CITY OF ALBUQUERQUE

March 6, 2017

RE: Taco Bell Heritage Marketplace
Grading and Drainage Plan
Engineer's Stamp Date 3-1-2017 (File: H09D026)

C1.1 - GRADING DETAILS

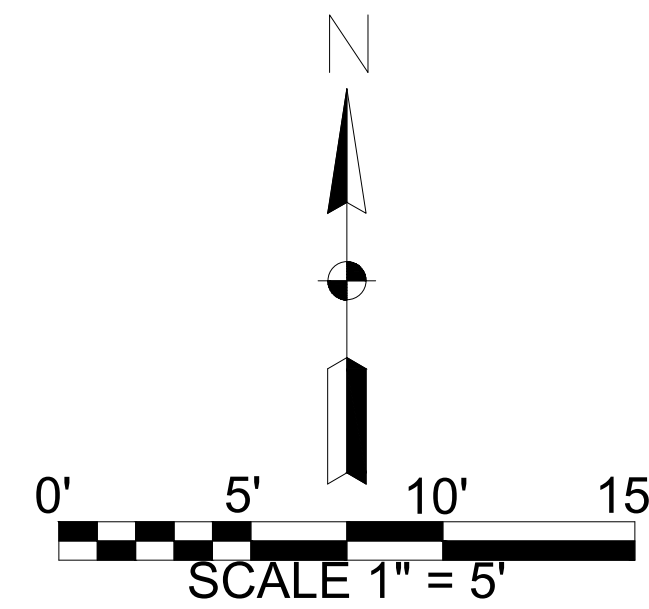
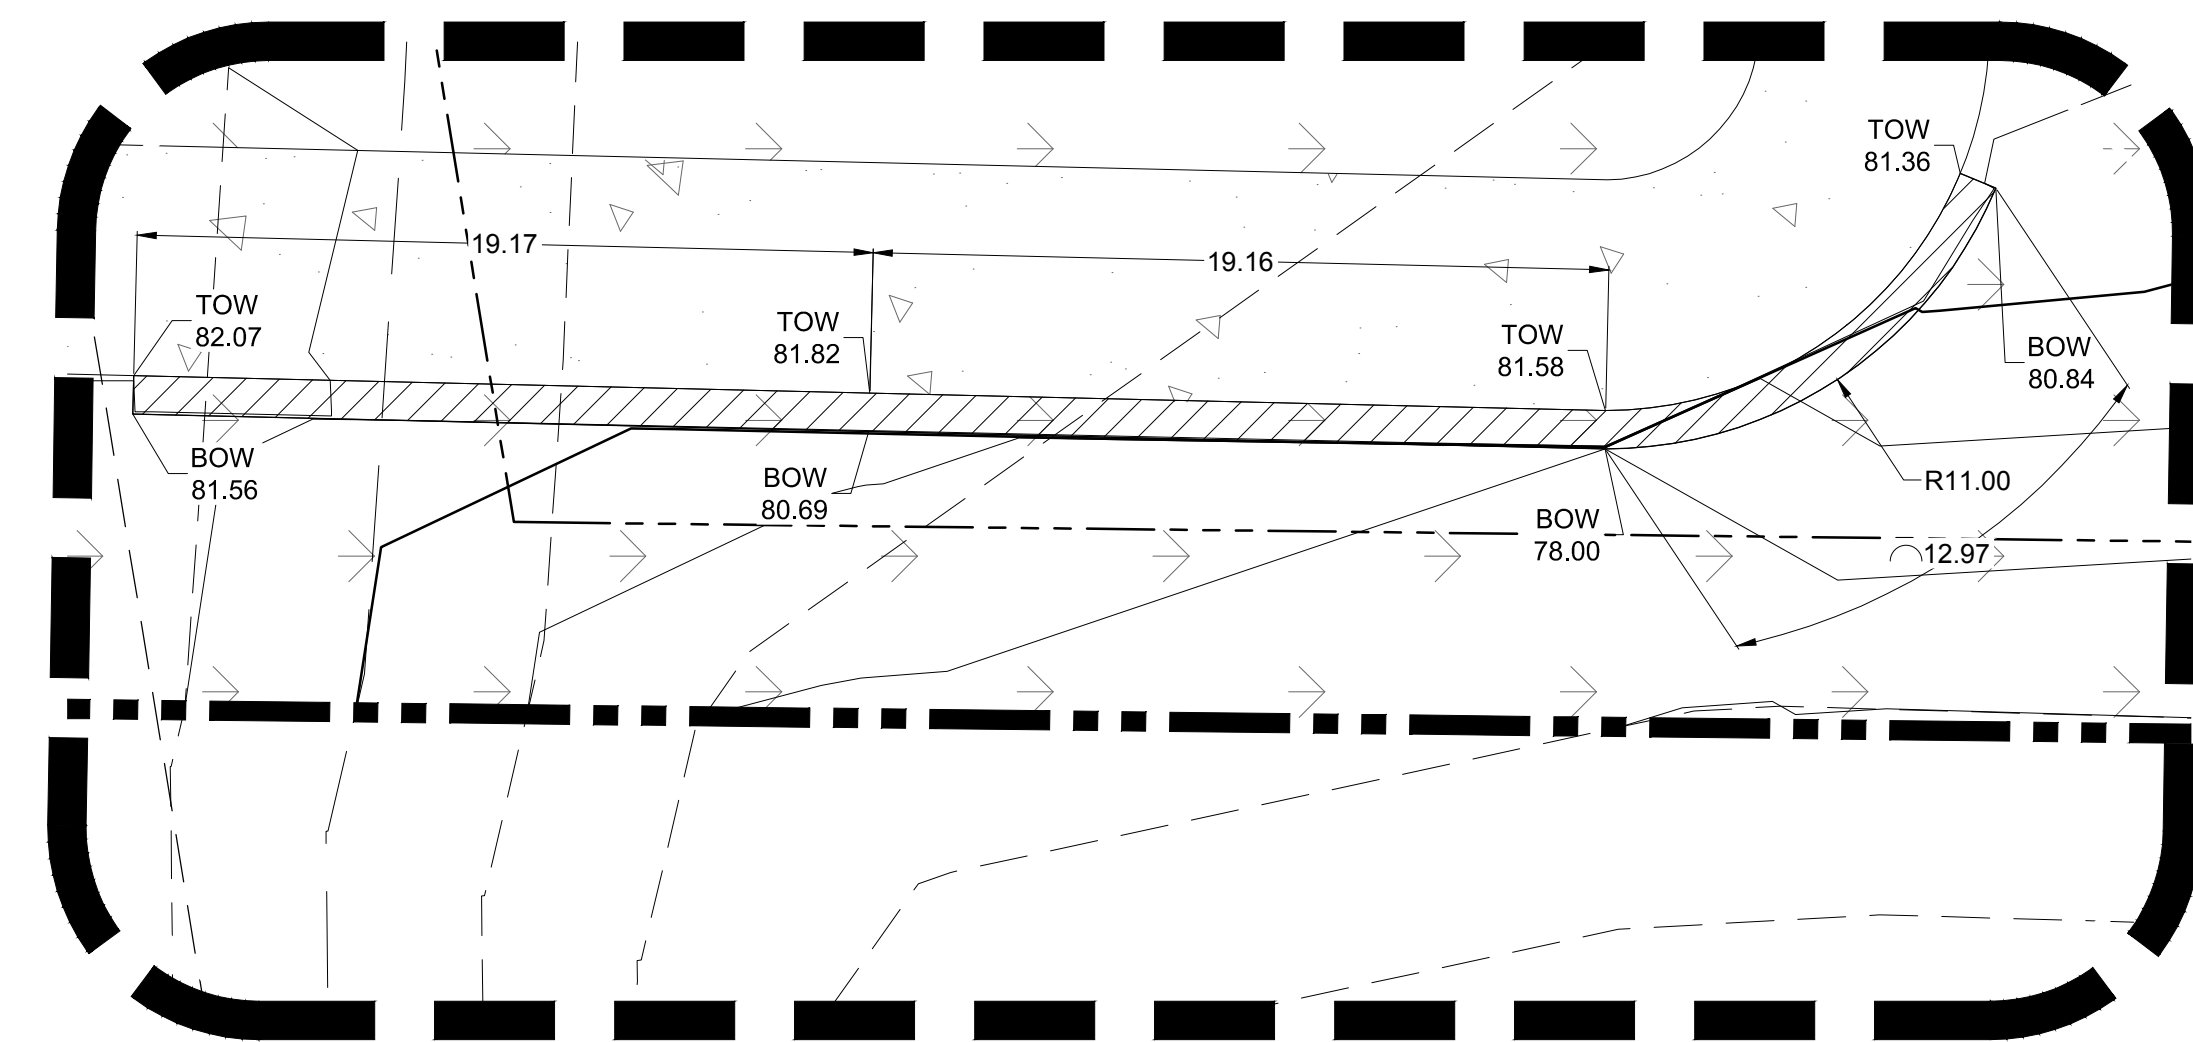
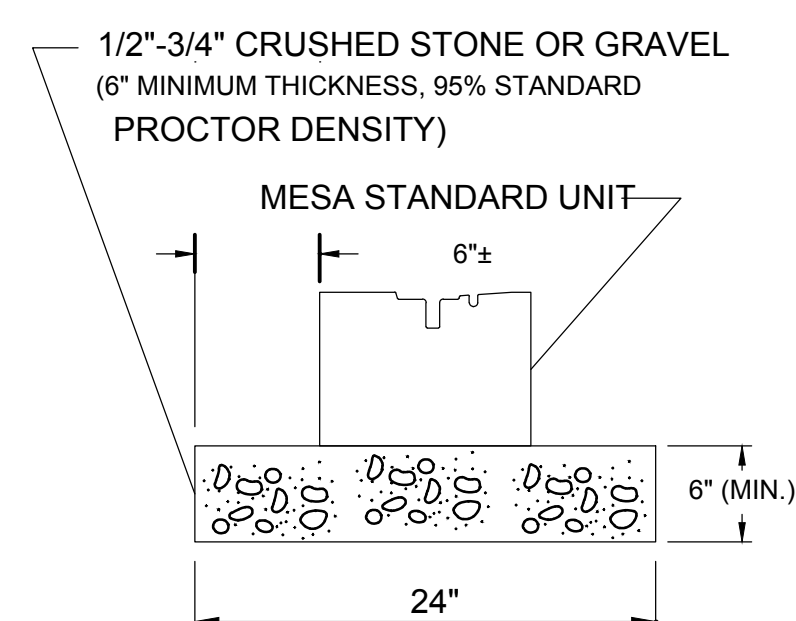
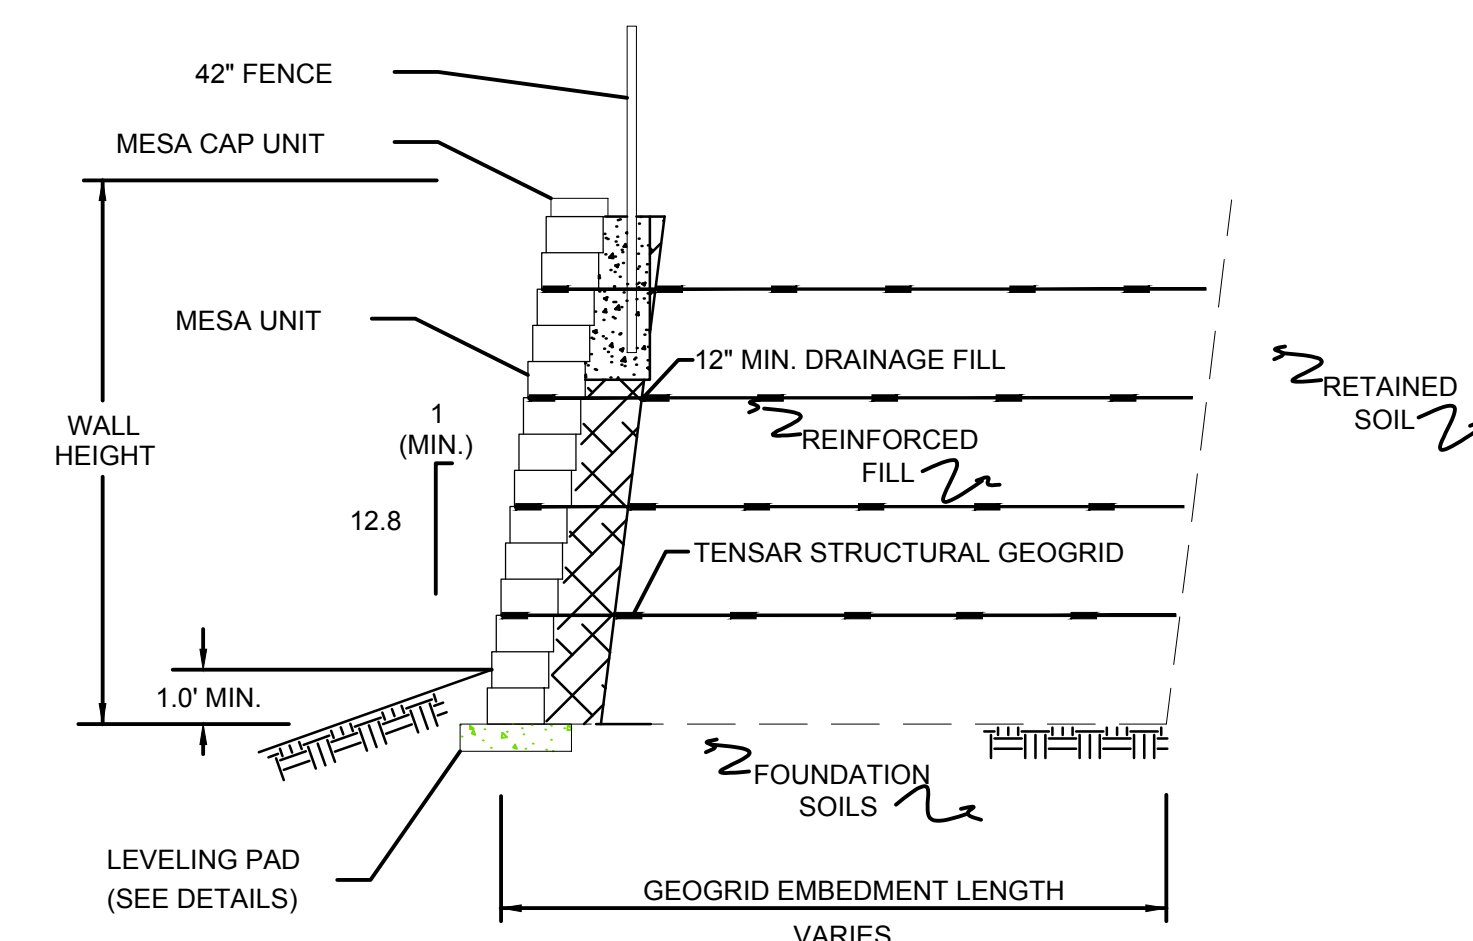
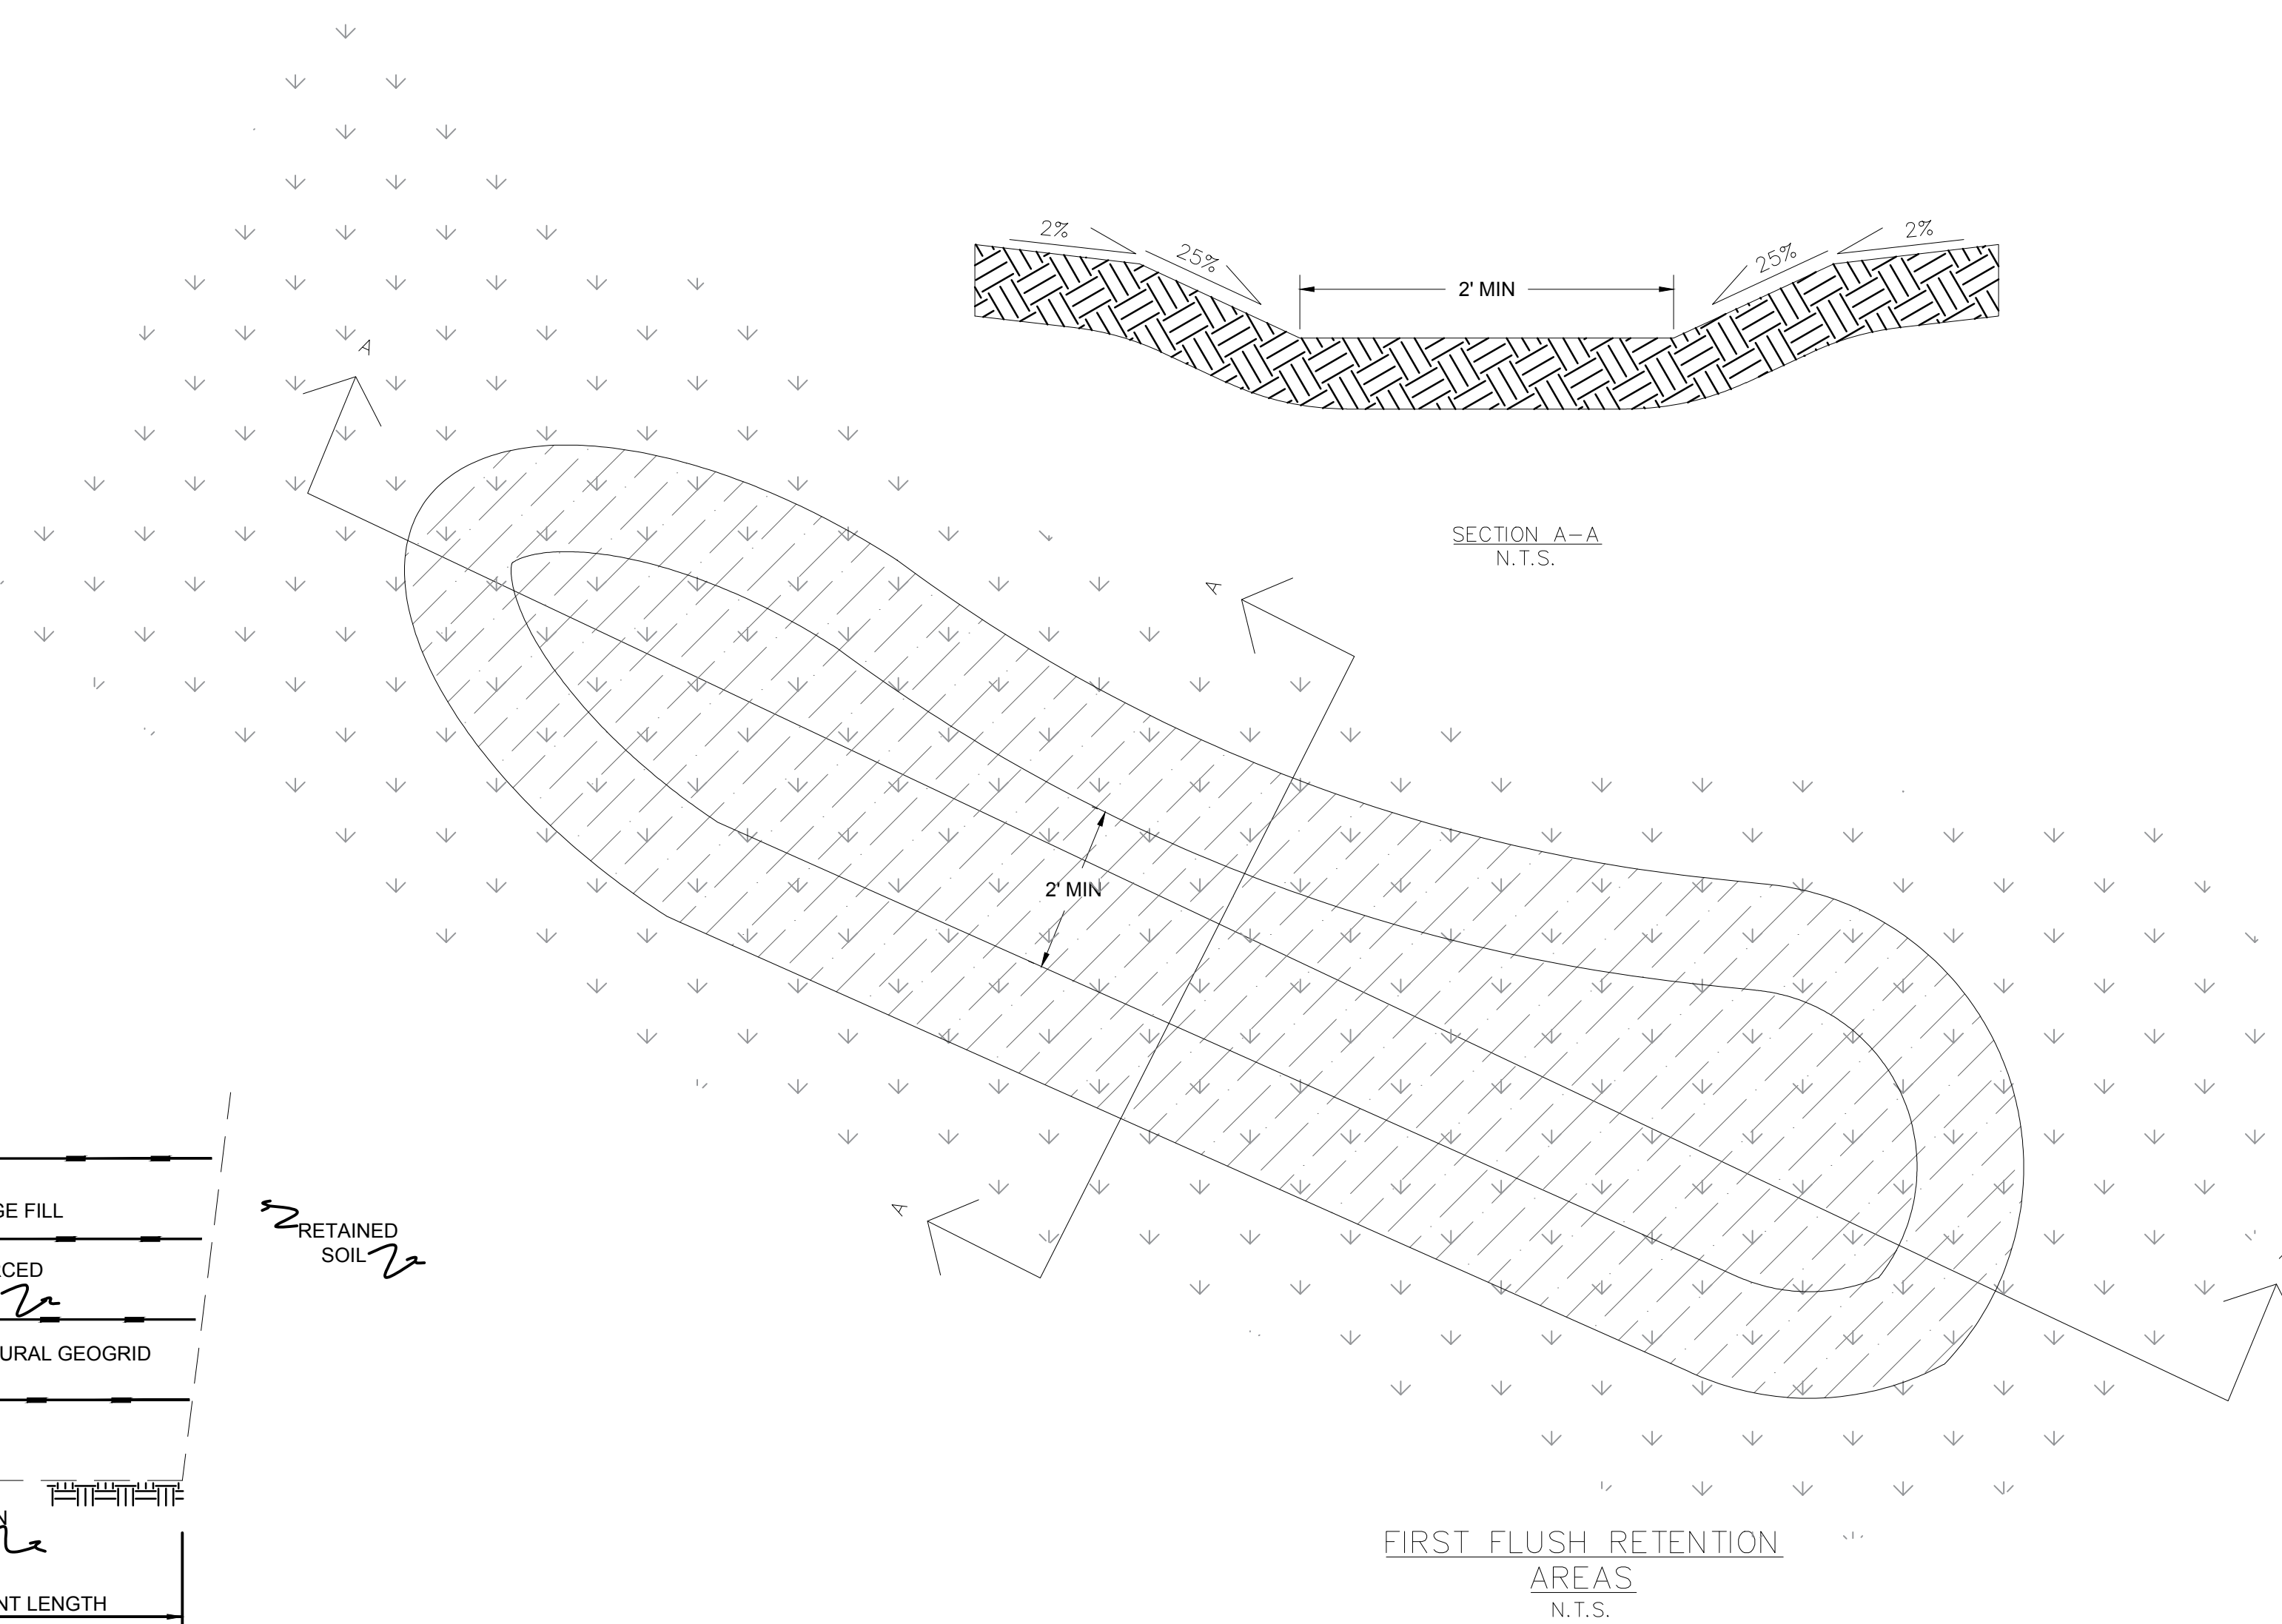
- Provide railing on top of the retaining walls where the drop is 18 inches or higher adjacent to a sidewalk.
